Addendum No. 1

RE: Contract # C204275
WBS # 15005.1092017
STATE FUNDED
Wake County
US-70 PIPE REPLACEMENT

PROJECT REFERENCE NO. 15005.1092017	SHEET NO. EC-3
RW SHEET NO.	
DOCUMENT NOT CONSIDERED FINAL UNLESS ALL SIGNATURES COMPLETED

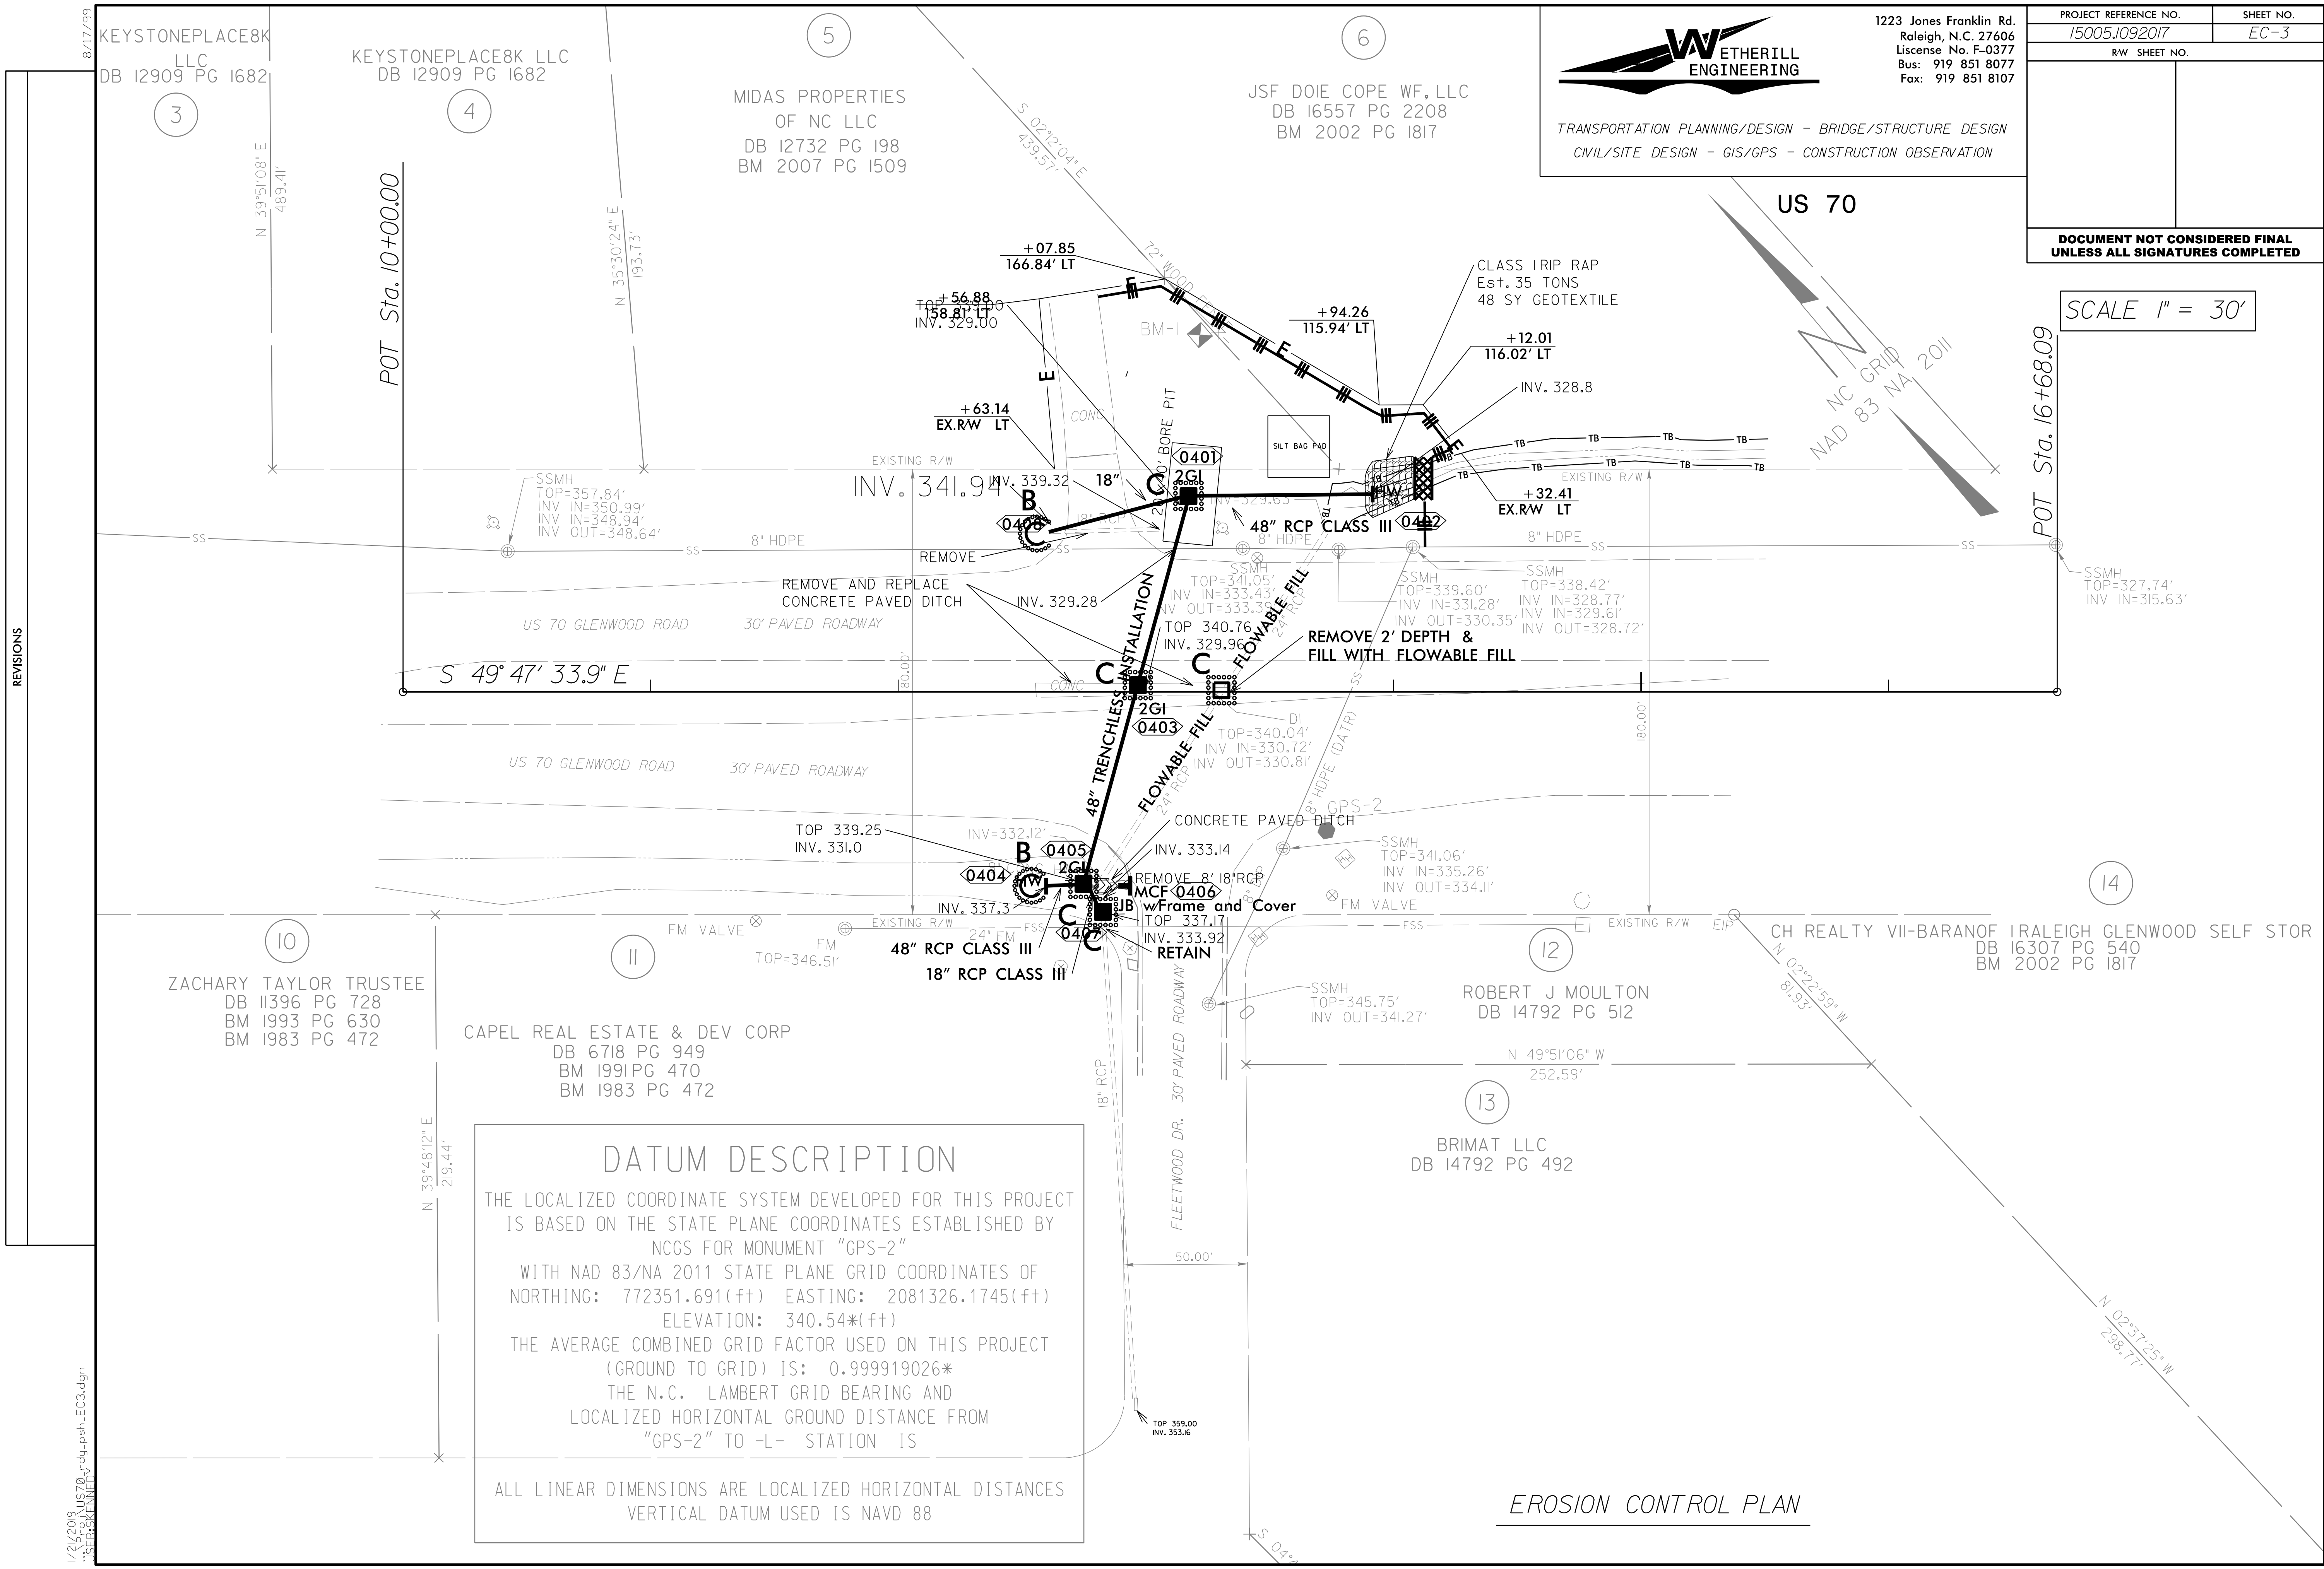
Sheet No.	Revision
EC-1	Revised name of Plan Reviewer
EC-3	Revised erosion control design
